**Consultation Response from KC,
Lead Local Flood Authority**

2025/90517 land off, Forge Lane, Thornhill Lees, Dewsbury, WF12

**Outline application, including the consideration of access and layout, for two commercial units
(use class B2 and/or B8) and associated works**

Date Responded: 29th July 2025

Figure 2: Environment Agency Flood Map for Planning

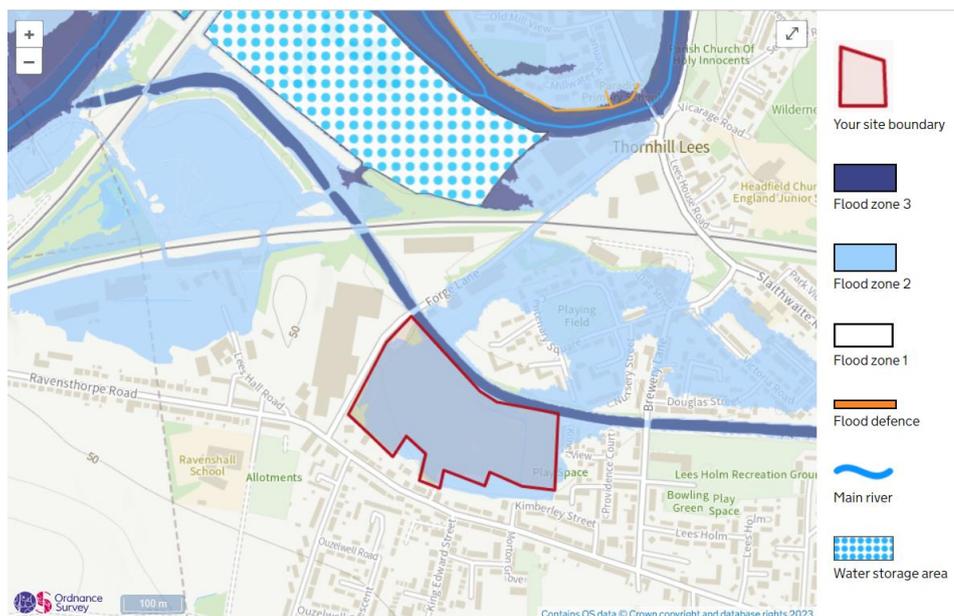
Kirklees Council is in the process of updating its Strategic Flood Risk Assessment to support updates to the local plan. This site is now shown to be vulnerable to flooding in the 0.1% annual probability of river flooding with an appropriate allowance for climate change, i.e. flood zone 3 with a climate change allowance. This was not the case in November 2024 when the submitted FRA and drainage plan was produced.

As such the planning officer may wish to re-run a sequential test to see if more appropriate sites are available for development first.
